Our ref: WX/2019/133441/01-L11
Your ref: TRO40011

**METROWEST PHASE 1 DEVELOPMENT CONSENT ORDER APPLICATION
EXAMINATION DEADLINE 4 – RESPONSE TO ISSUE SPECIFIC HEARING 3
ACTION POINTS**

Please find hereunder the Environment Agency's responses to the pertinent Action Points raised in respect of ISH 3 agenda item 5 (Flood Risk, Drainage and Contaminated Waters):

2.41 - Easton-in-Gordano Flood Mitigation Plan

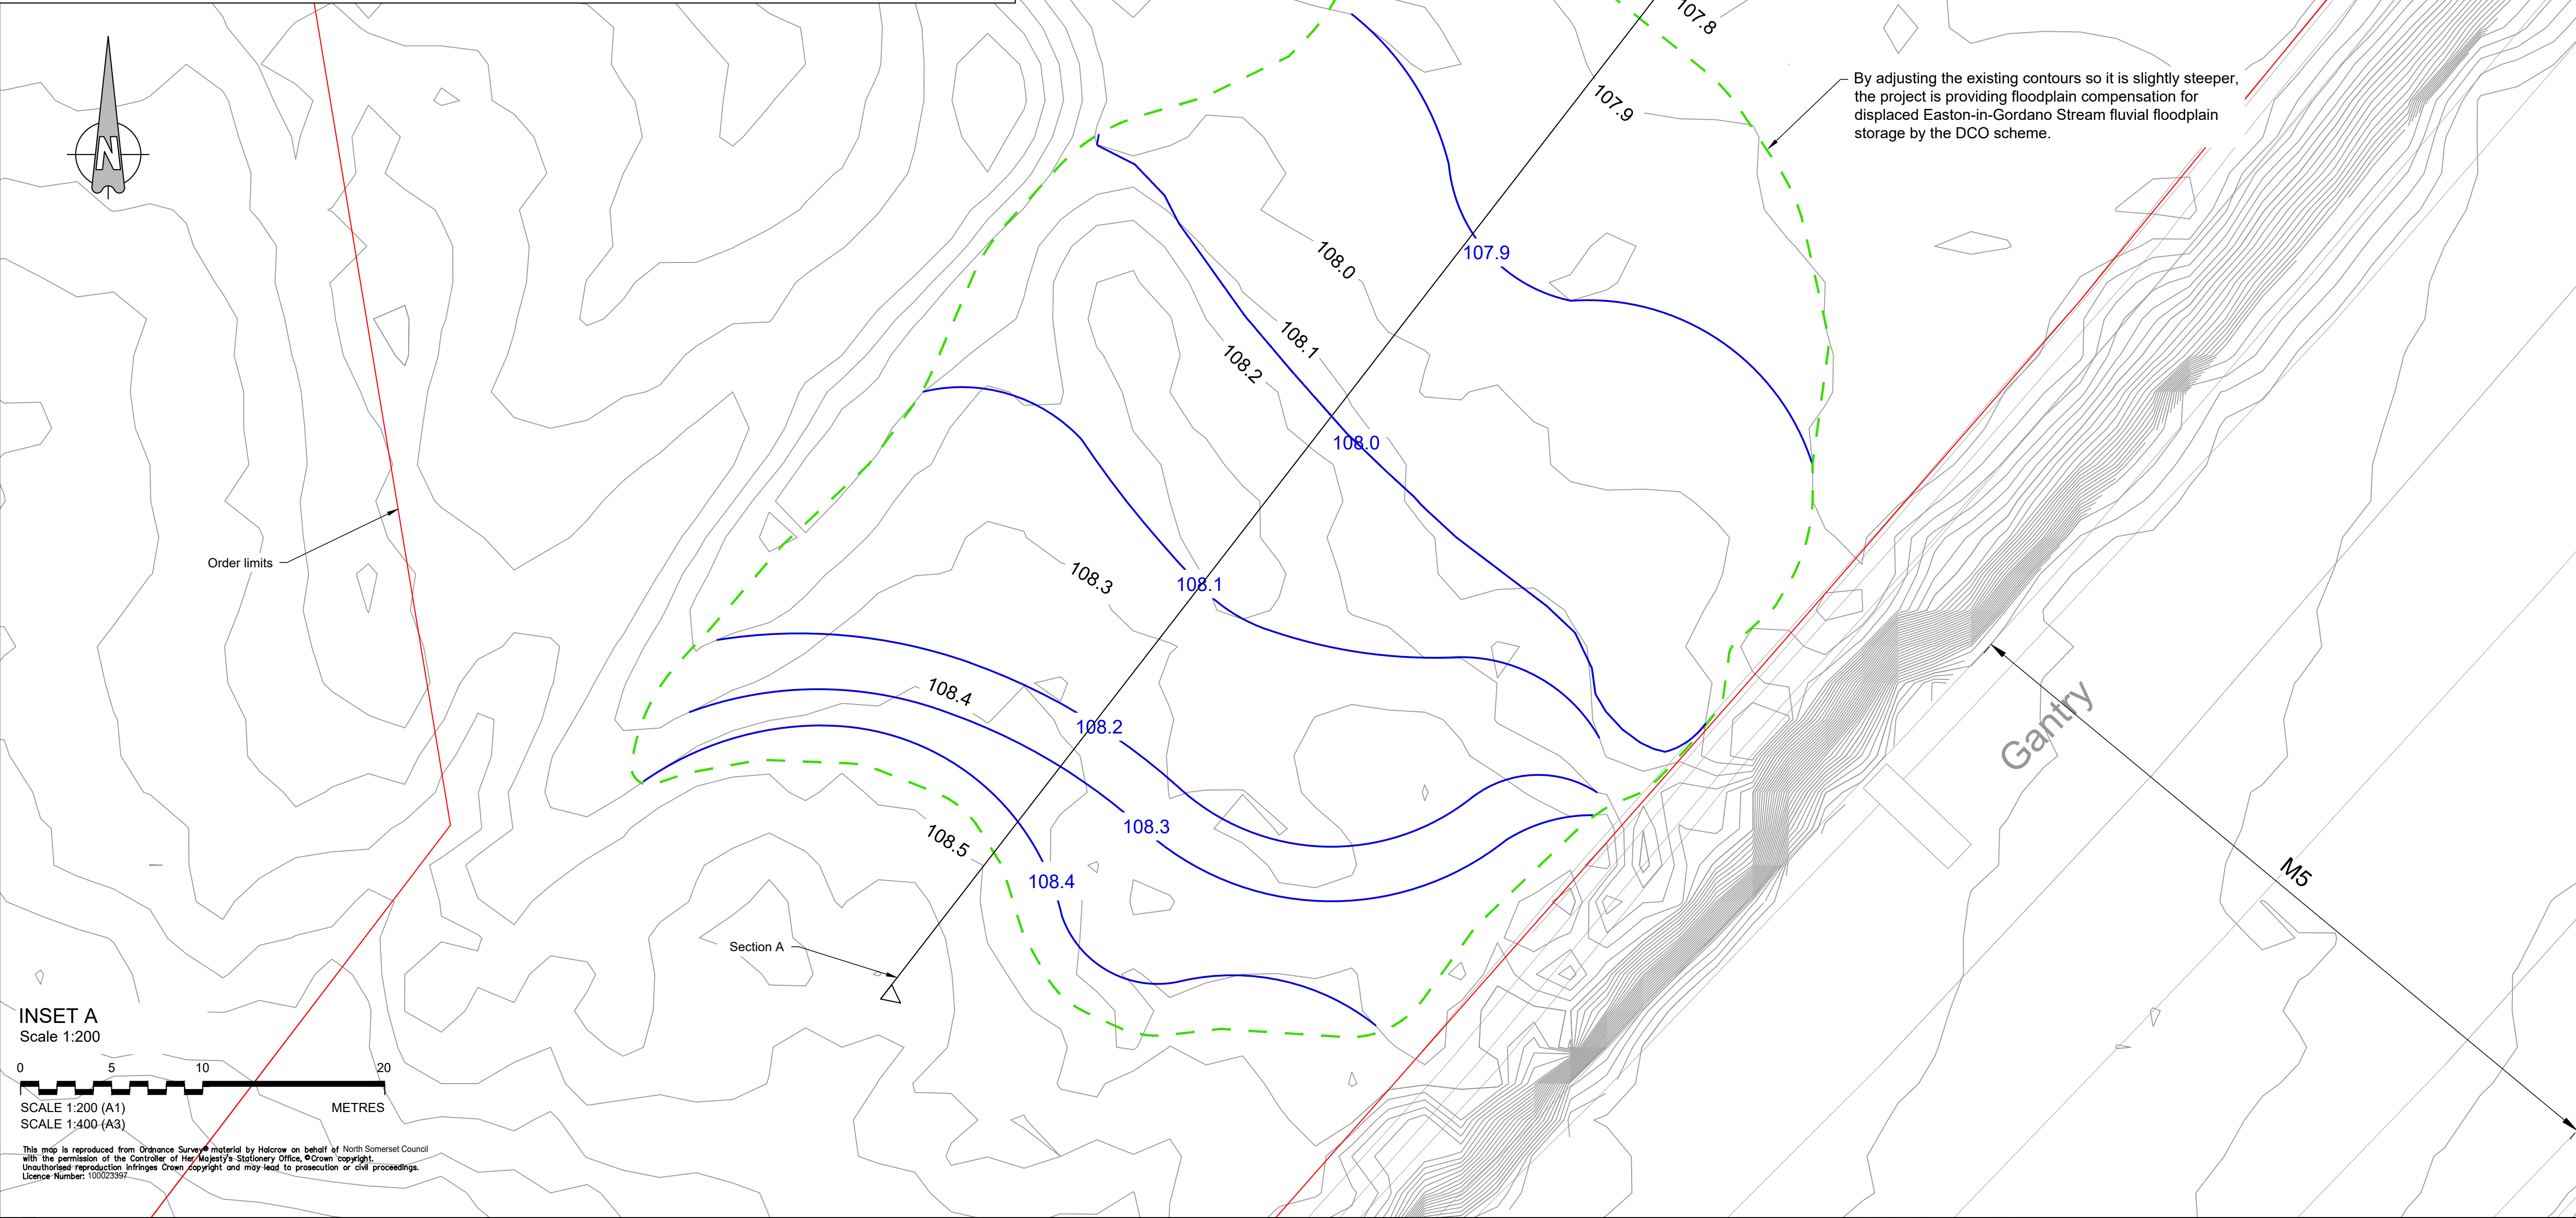
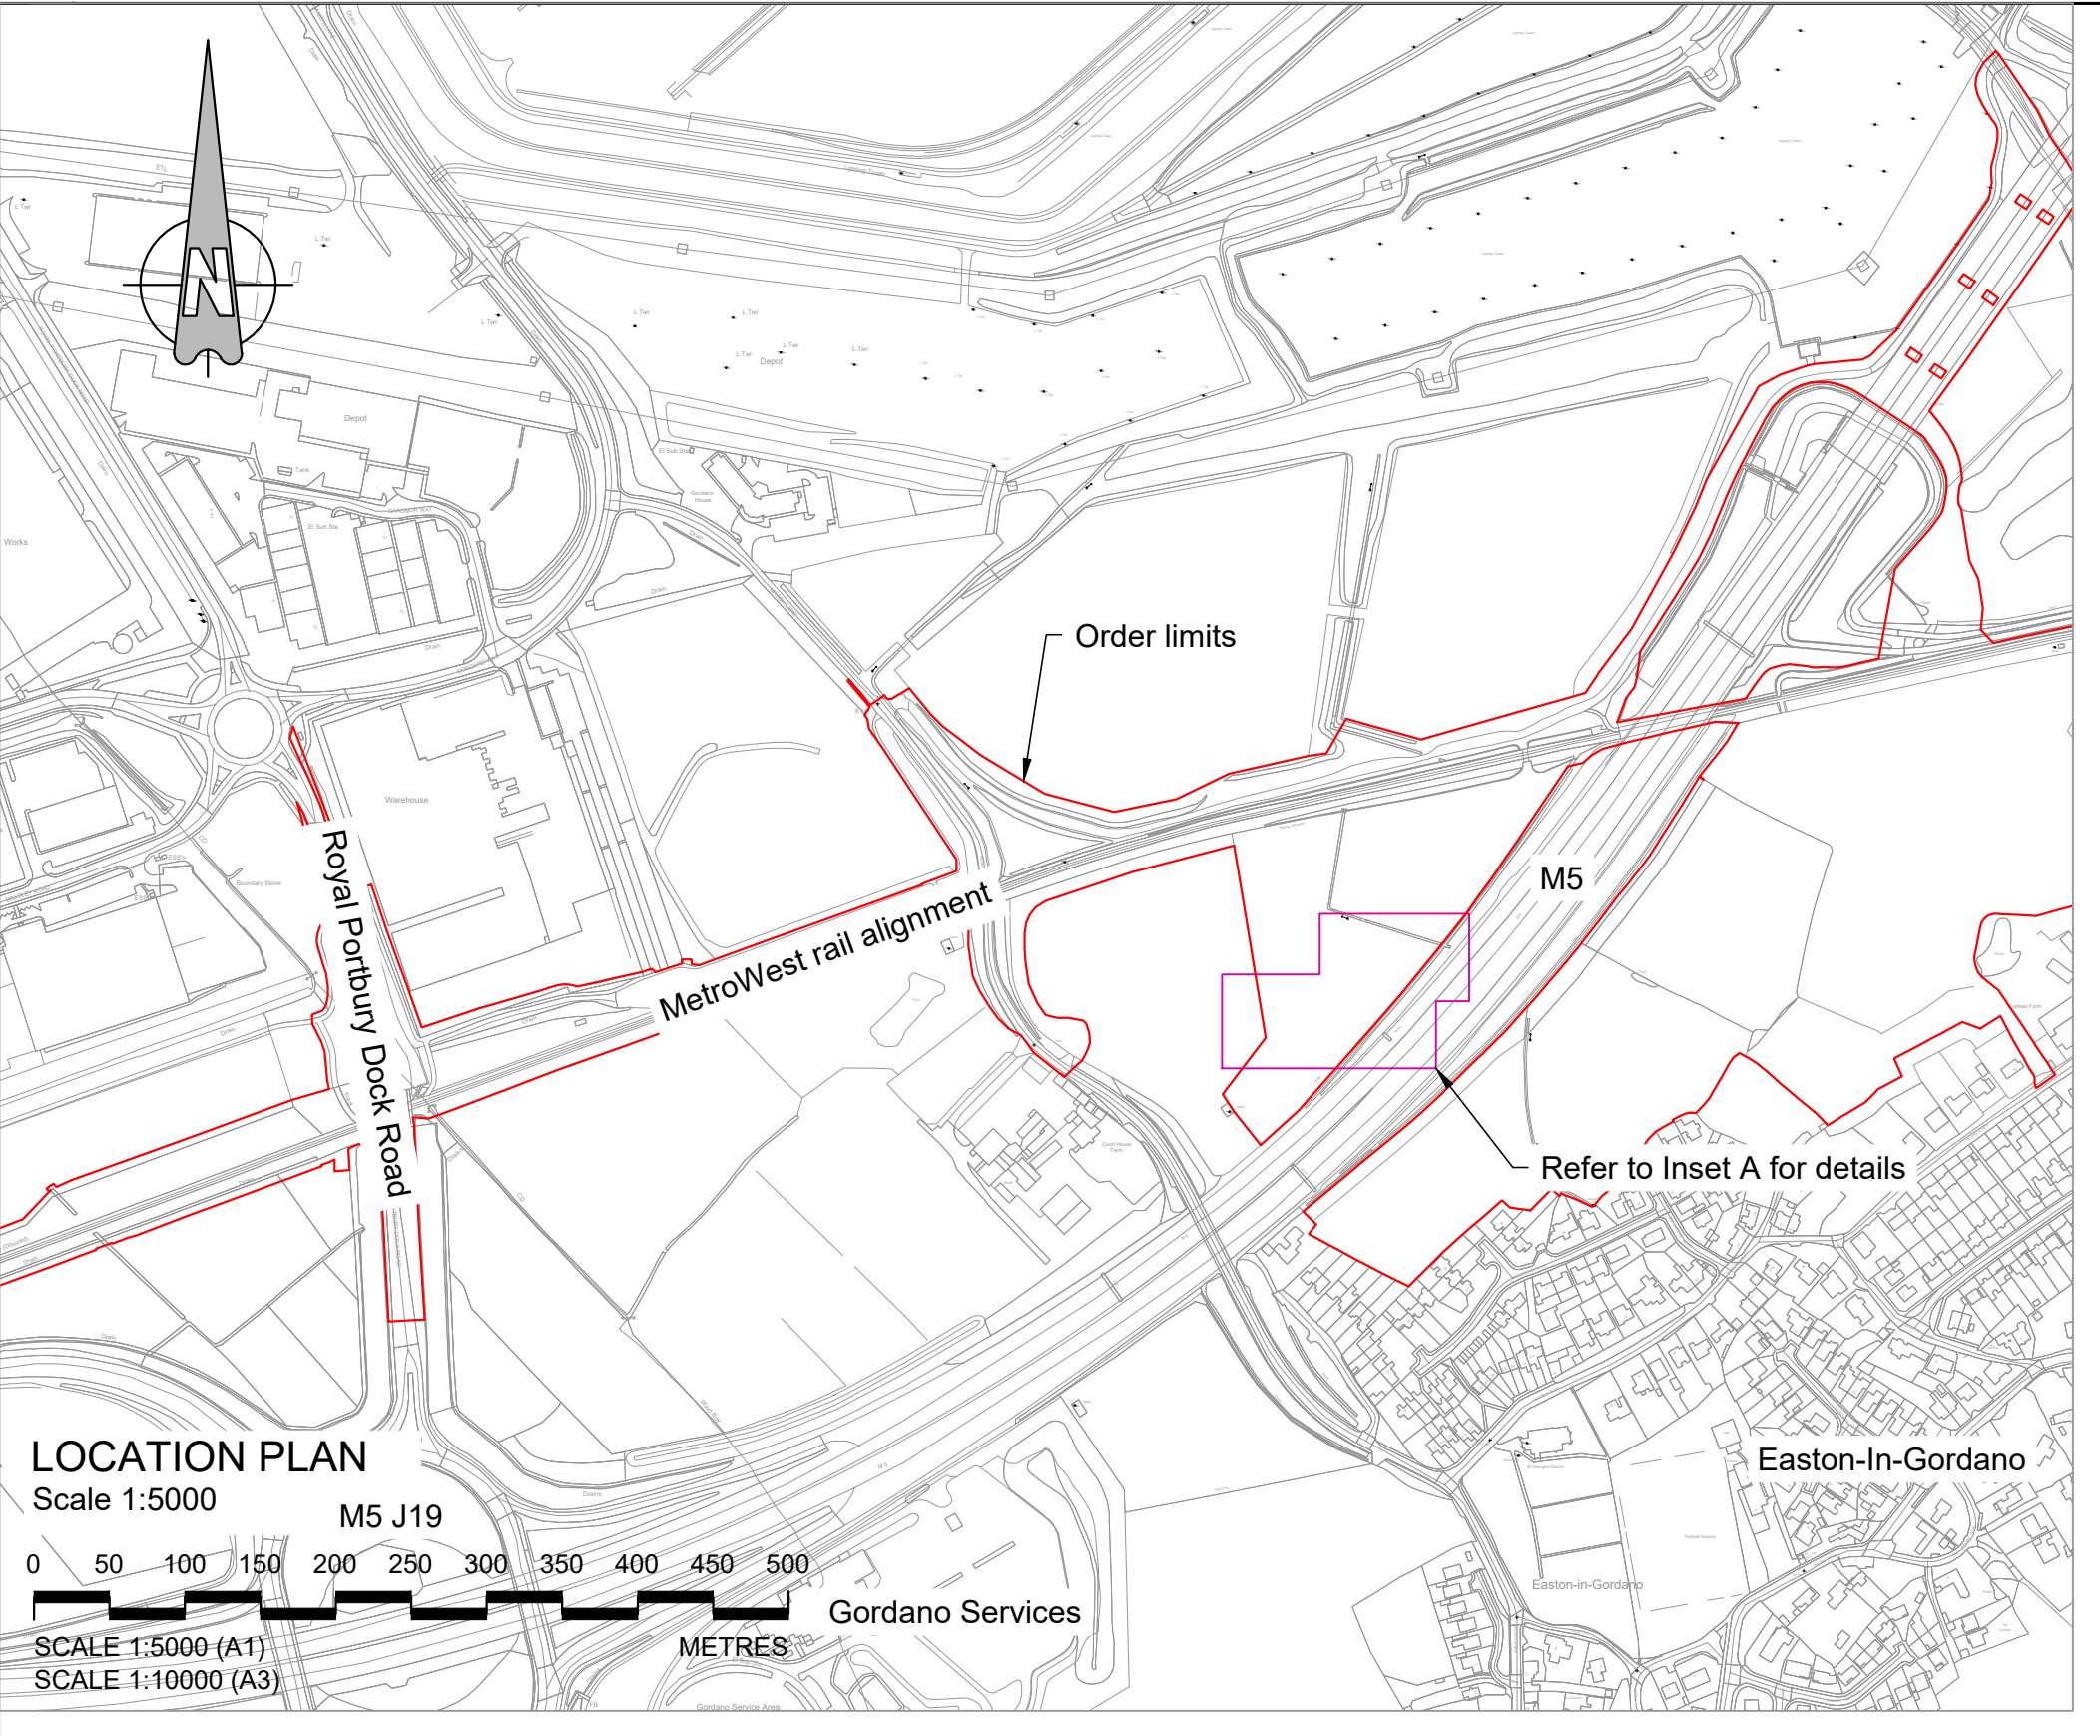
The bridge width and ground level must not be changed during the lifetime of the development, on the grounds it is viewed as essential for ensuring floodwater flows from one side of the railway to the other. This arrangement therefore provides a degree of line safety from the risk of flooding. The Agency will require confirmation from the applicant regarding the means by which the above requirement will be secured.

Figure N-3: Pre Development, 20year return period event in 2015 ,Tidal

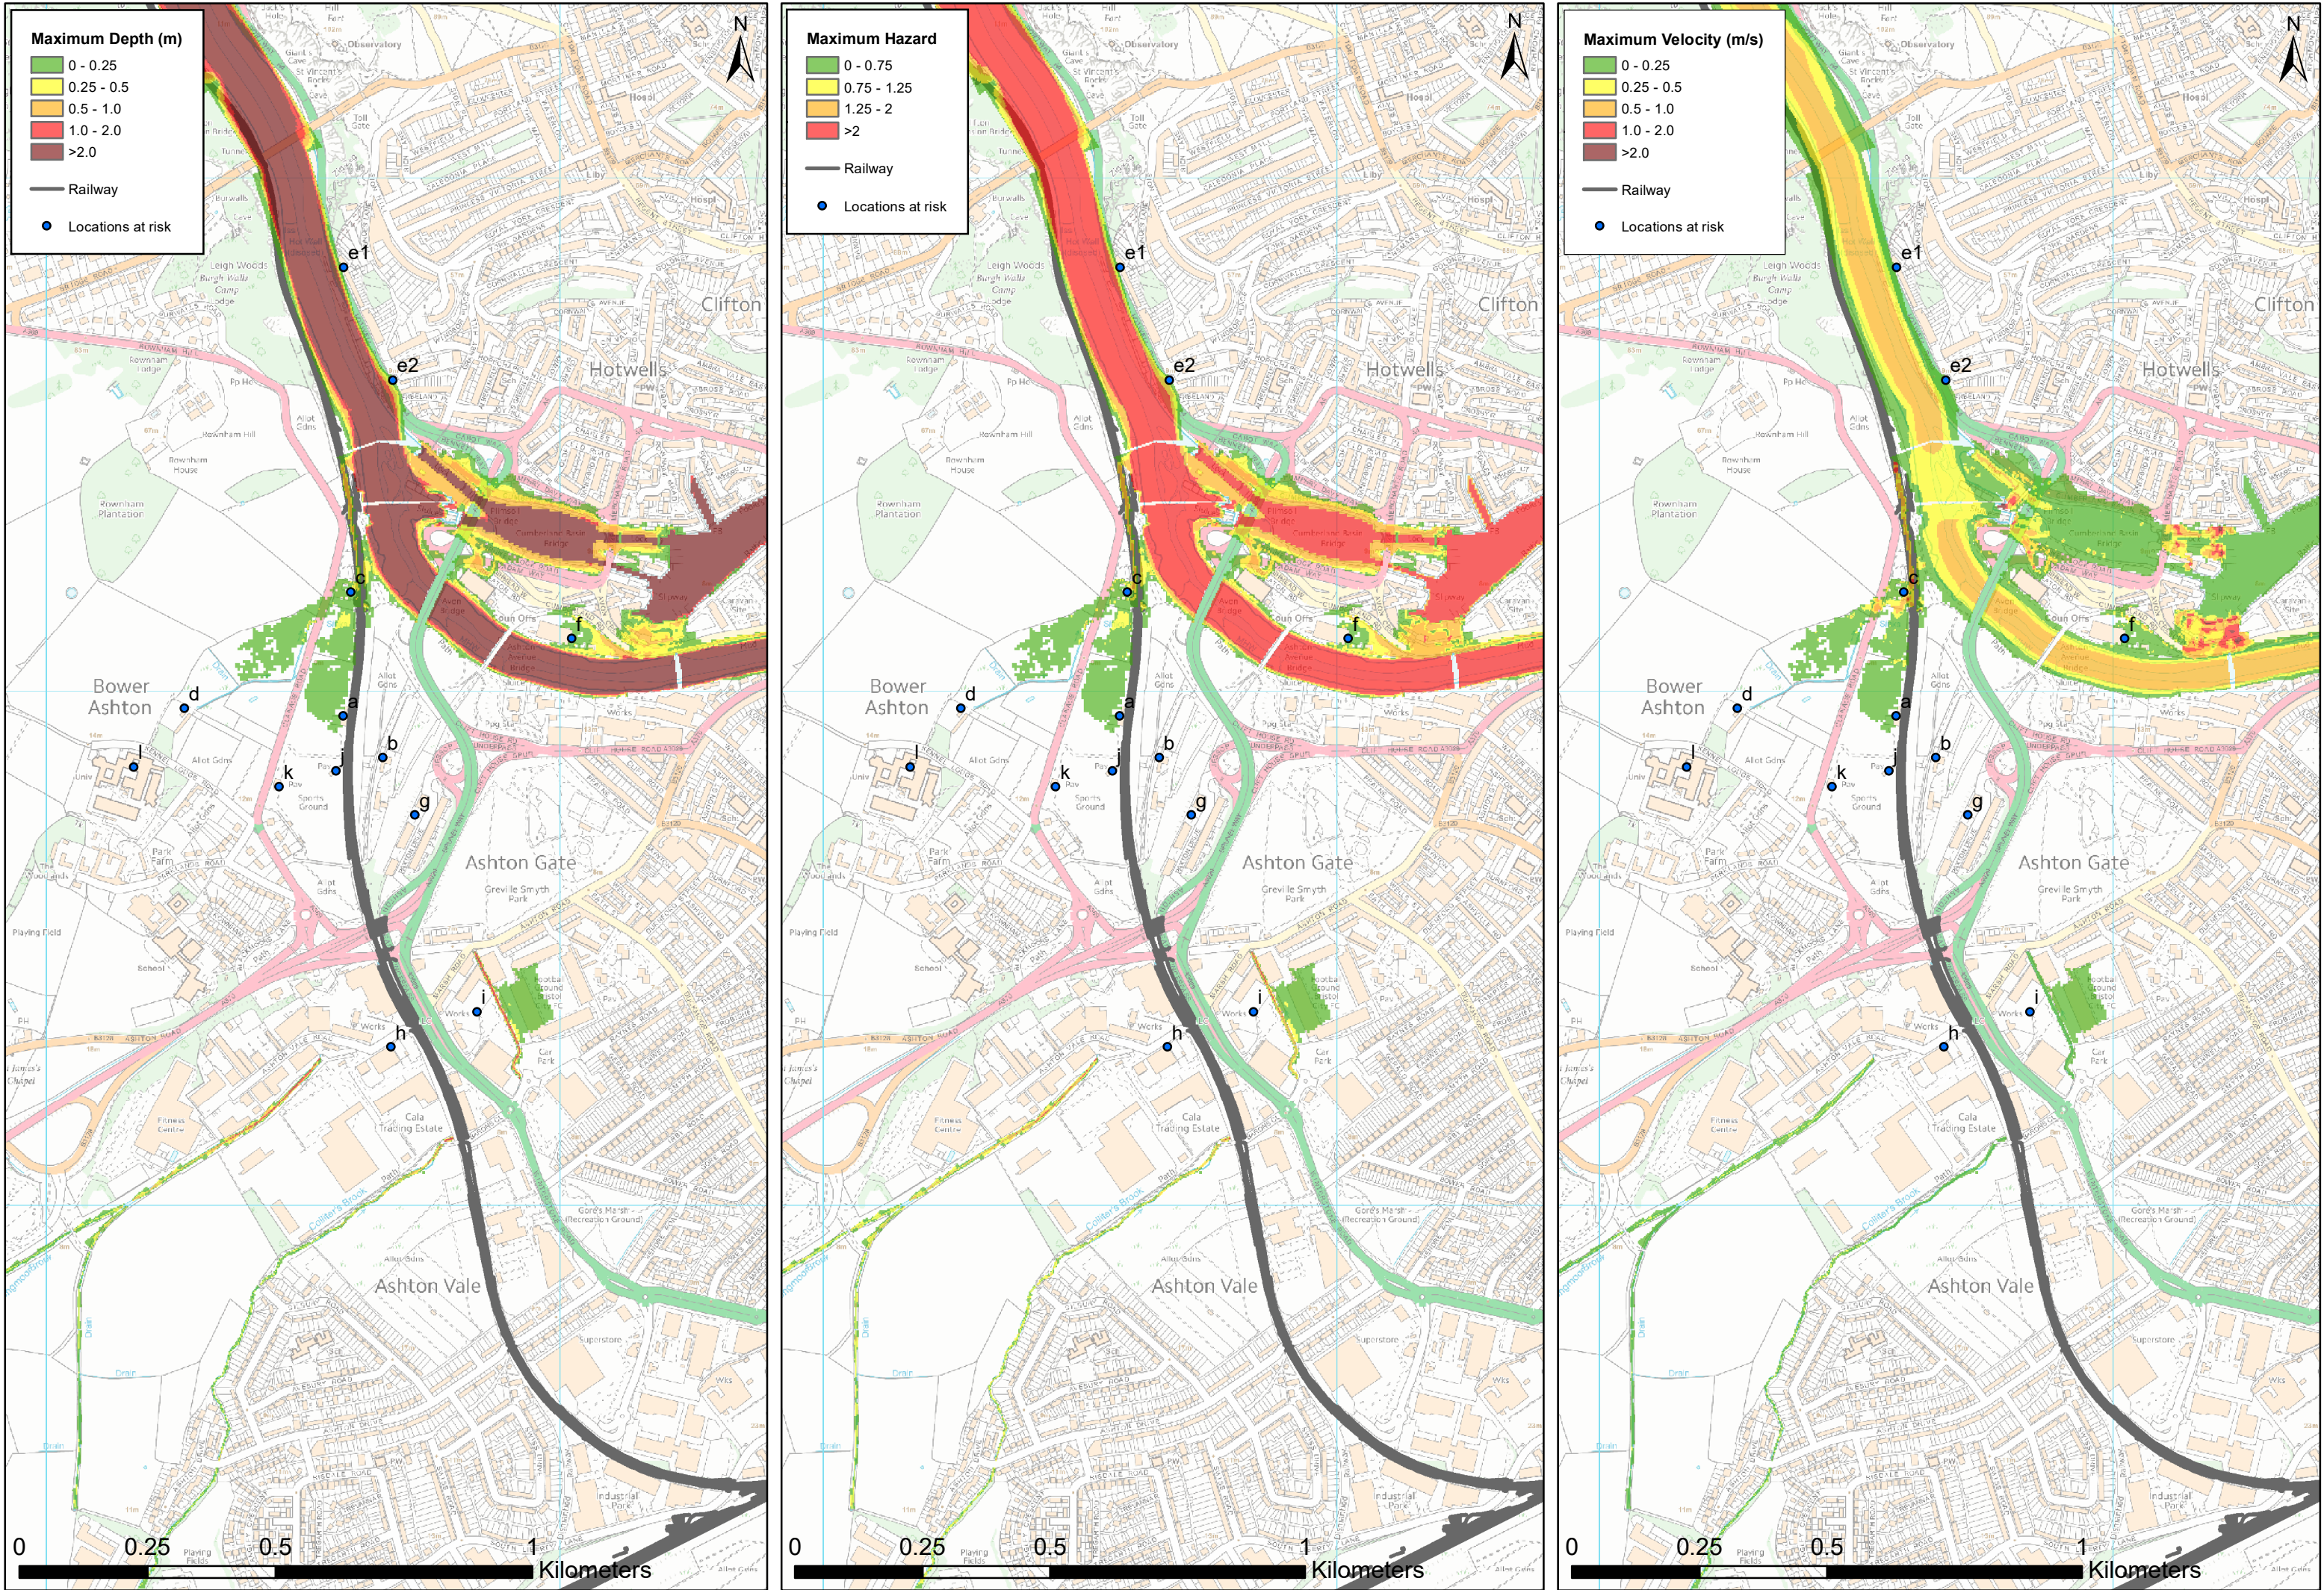
4.2.10 Appendix N, DCO Document Reference 5.6 includes flood maps for the simulated events. These flood maps show the proposed Clange Road compound to be within the 20-year tidal River Avon flood extent, and outside of the tidal River Avon 10-year flood extent i.e. within simulated Flood Zone 3b.

The map below, extracted from appendix N part 2 Figure N-3, shows the 20 year return period event in 2015 tidal flood map also called the functional floodplain.

250 mm flooding at Clamage Road compound for a 1 in 20 year present day tidal event.

Further, if the model is over predicting, how accurate is the model at establishing floodplain compensation requirements, especially at Clanage Road? It is worrying to note the applicant's contention that the floodplain compensation provision at Clanage road is within model error.

Lowering the ground level at the Clanage Road compound will increase the flood depth on the site and with the compound considered to be within the functional floodplain, it restricts what the applicant would be allowed to do on the site.

The Agency understands the entire compound area needs to be lowered to provide enough floodplain compensation. The welfare unit proposed on the compound area will need to be raised off the ground with a void underneath, to maintain flood water capacity. In addition, no materials of any kind would be allowed to be stored at ground level within the compound area, again, to maintain floodwater capacity at any time. If the applicant is unable to adhere to these strict requirements, the compound should be relocated.
